**Re: AW/246/19/PL – Erection of 1 No. 2 Storey End of Terrace House at land adjacent to 34 Wakefield Way, Bognor Regis PO21 3RS**

Reference: - AW/246/19/PL – Erection of 1 No. 2 Storey End of Terrace House

### **OBJECTION TO THE AFOREMENTIONED APPLICATION**

PROJECT	Wakefield Way	DATE	19/08/19
TITLE	Site Plans	DRG NO	IBA/520/01
SCALE	As Noted	REVISIONS

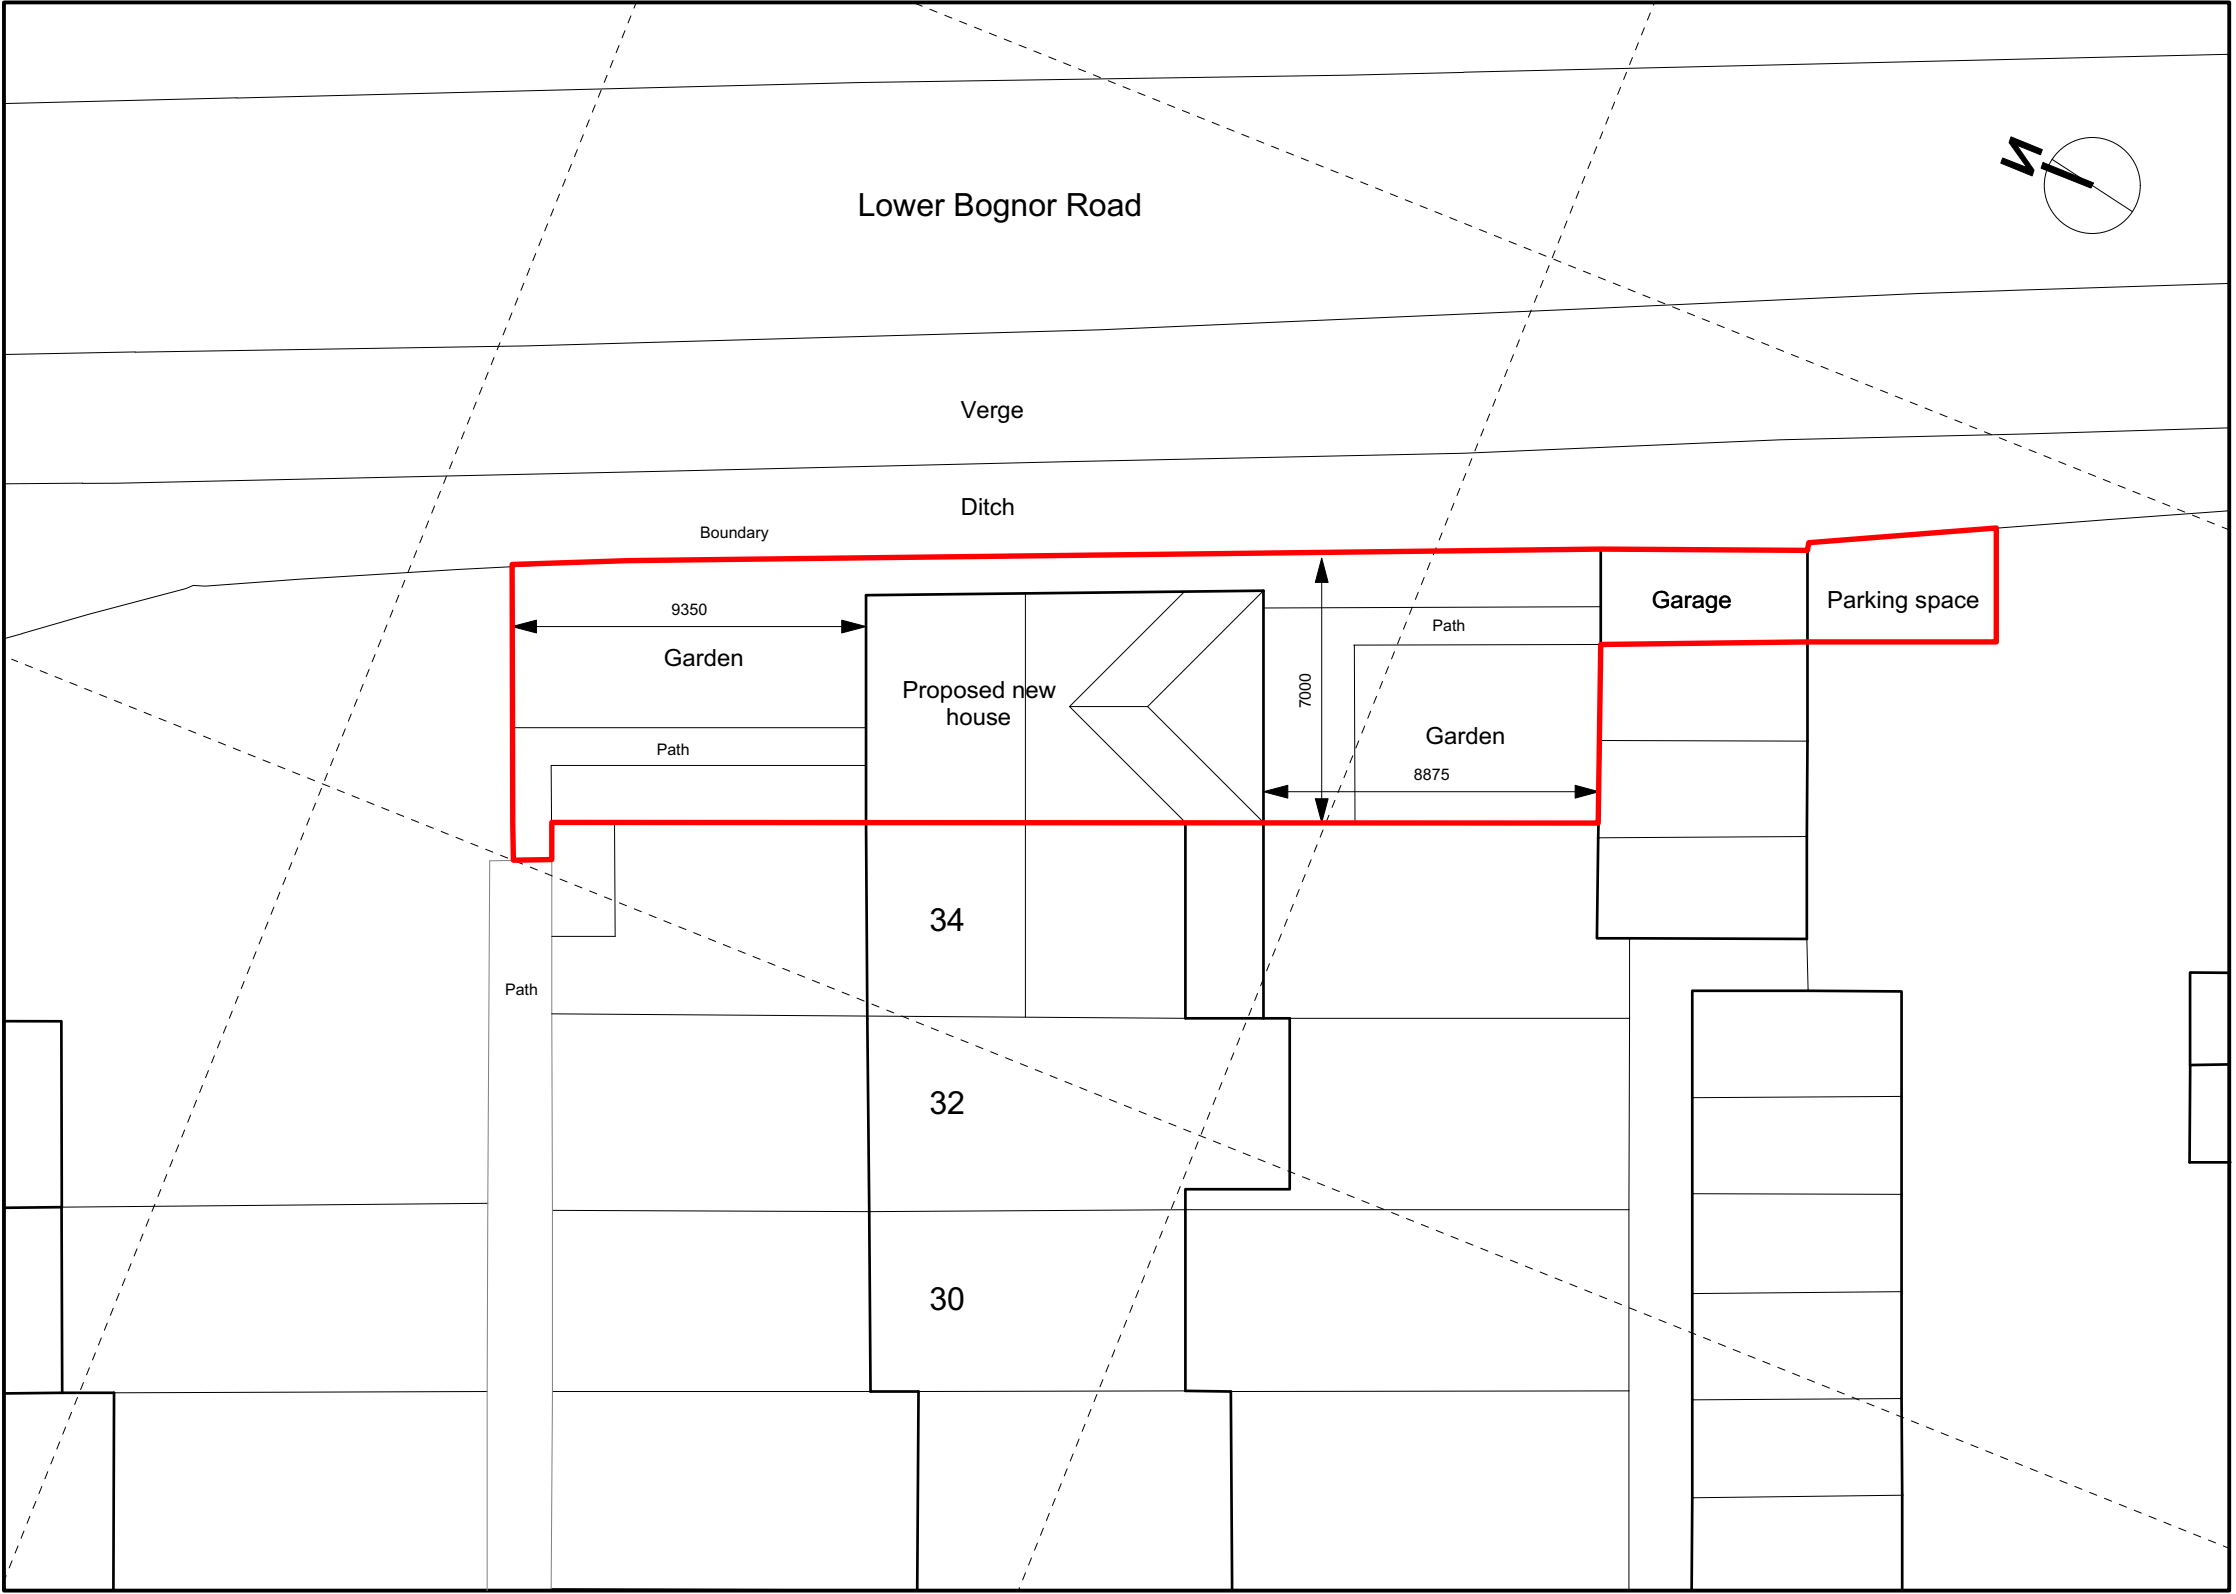
I refer specifically to IBA Drawings IBA/520/01, 02 & 03.

In paragraph 2 of the Design and Access Statement on Page 5 of the self-named document, I quote *"Parking is provided on site, with one garage space and one parking space in front of the garage"*

According to the WSCC Consultation on the planning application the WSCC PDC **requires** a minimum of three parking spaces to be provided for this size dwelling in this location.

The first of which is a garage situated at the far end of the L/H side of the garage block. This garage is apportioned to No.34 (the existing dwelling) therefore no "additional" space has been created, it has simply been re-assigned from an existing dwelling to the proposed. This conclusion has also been noted within the WSCC Consultation.

There is also a further point to the proposed use of a garage as a parking space within this application. As per the WSCC Consultation, the garage in question is only 2.5m wide and 5.5m long. This is barely big enough for a standard size family vehicle. However, the Design and Access Statement submitted makes note that the garage will also be the "Bin Store" for three wheeled refuse bins along with space for two bicycles. I do not see how a car, three wheelie bins and two bicycles will fit into this garage. The floor space is simply not enough.

Secondly the area of hard standing in front of the garage cannot be assigned to any one property as it does not fall within the ownership boundaries of the existing dwelling.

In short, no provision of any spaces has been provided for the new dwelling, therefore not meeting the regulatory 3 spaces as set down by the WSCC in their PDC.
